Application Number: 2011-287
CBL: 112-H-1
Project Name: cPort Credit Union
Address: 285 Forest Avenue

285 Forest Ave – Cport Credit Union – 112-H-1 – B-2 Zone - #2011-287

The proposal is to demolish the existing Arby's building and replace it with a credit union with 2 drive-thru lanes. This property is not adjacent to or abutting a residential zone or use. The use is an allowable use in the B-2 Zone in which it is located.

**A400**

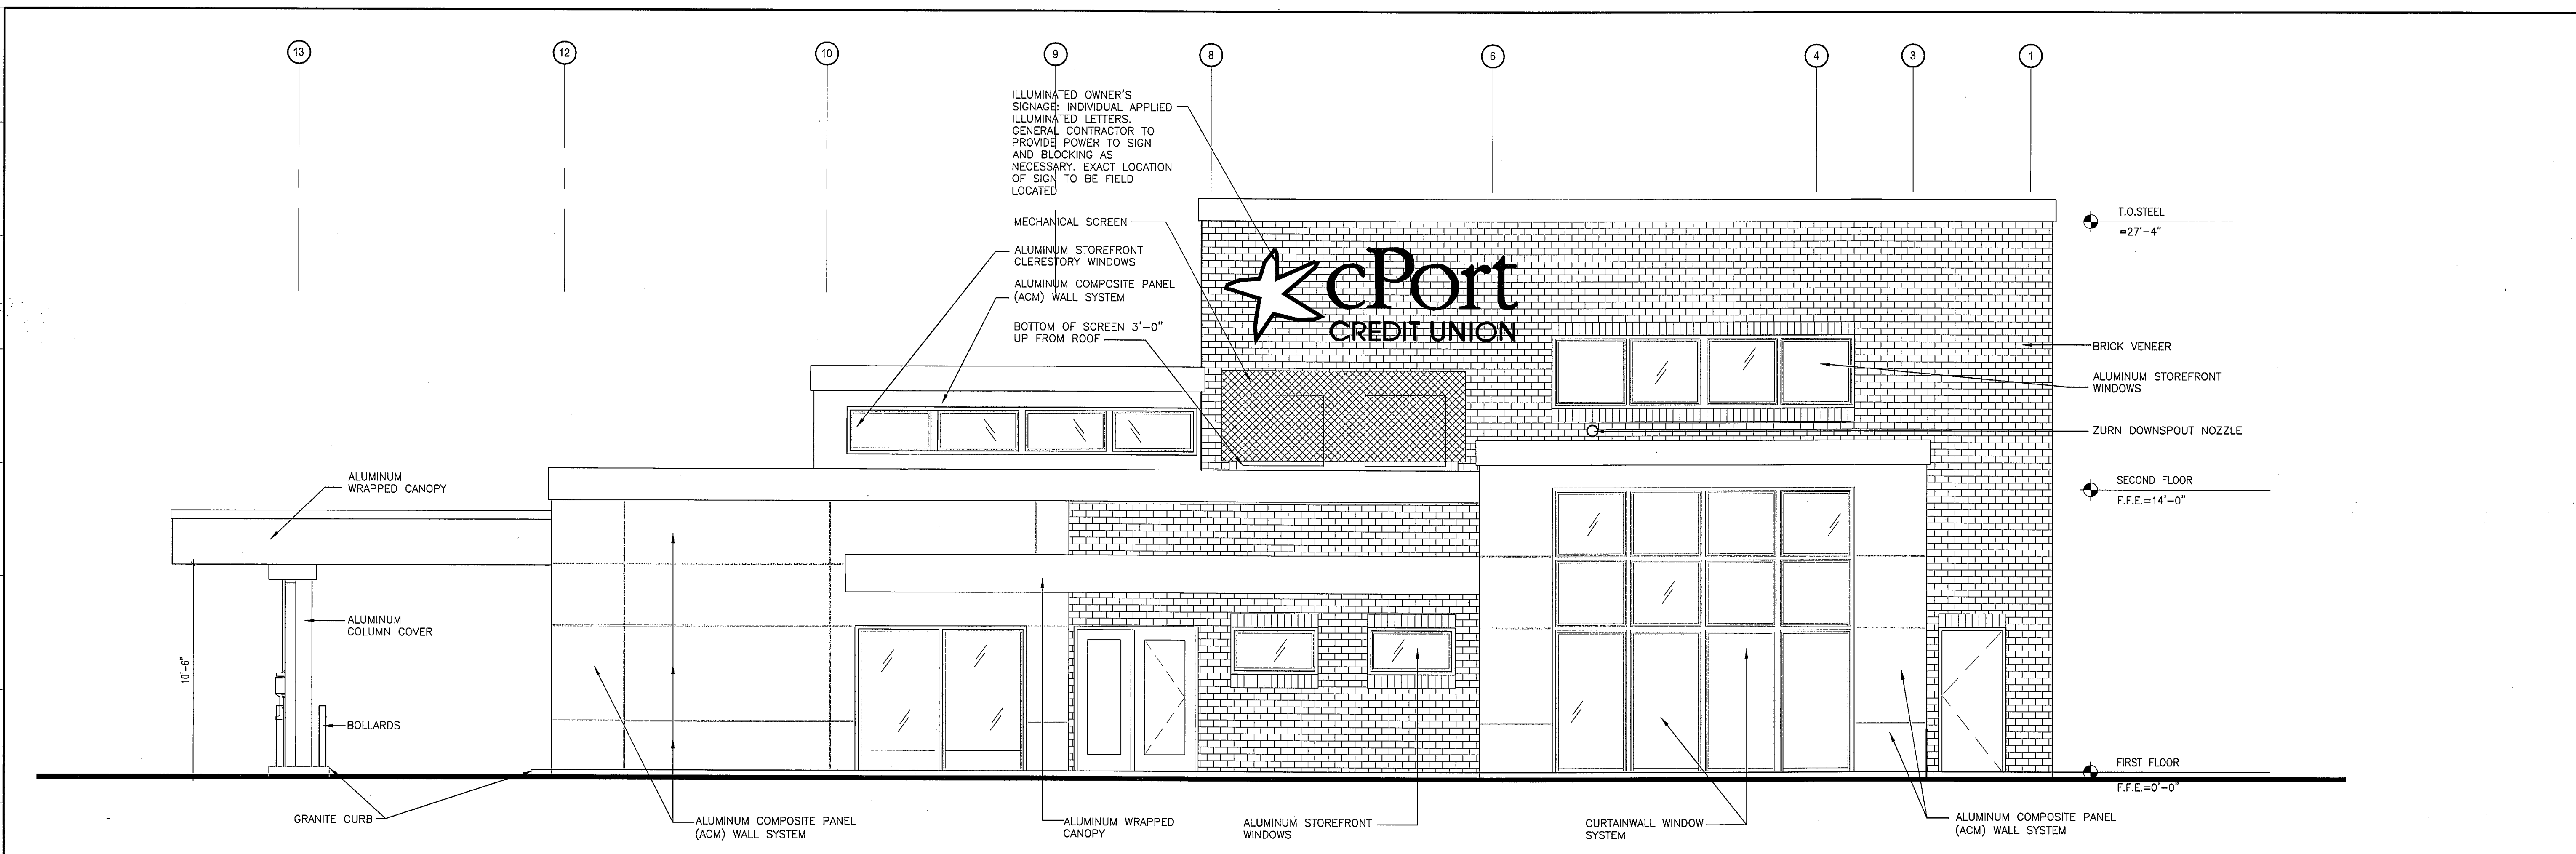
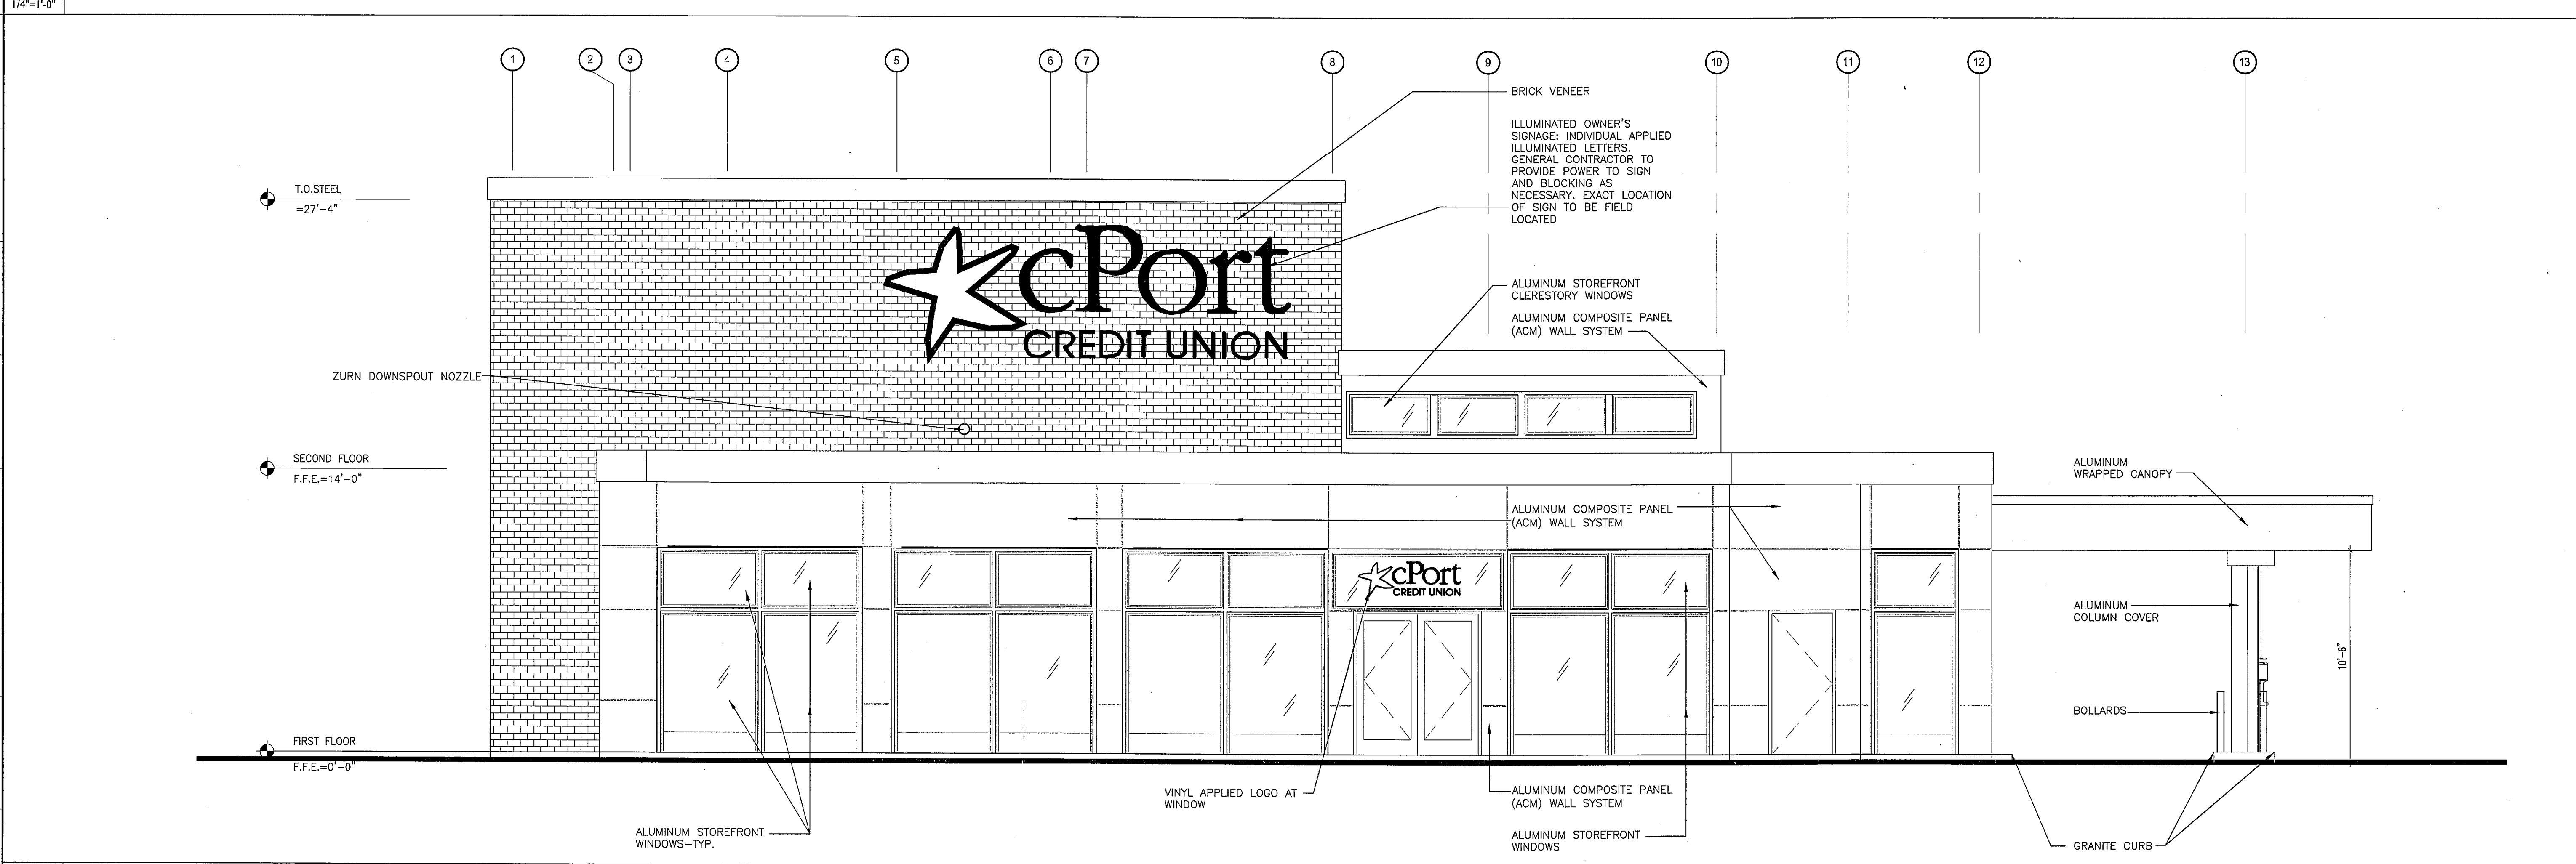
I did not see a building elevation in the e-plans. I would imagine that this site can meet the maximum height of 45 feet. I would like to confirm that requirement.
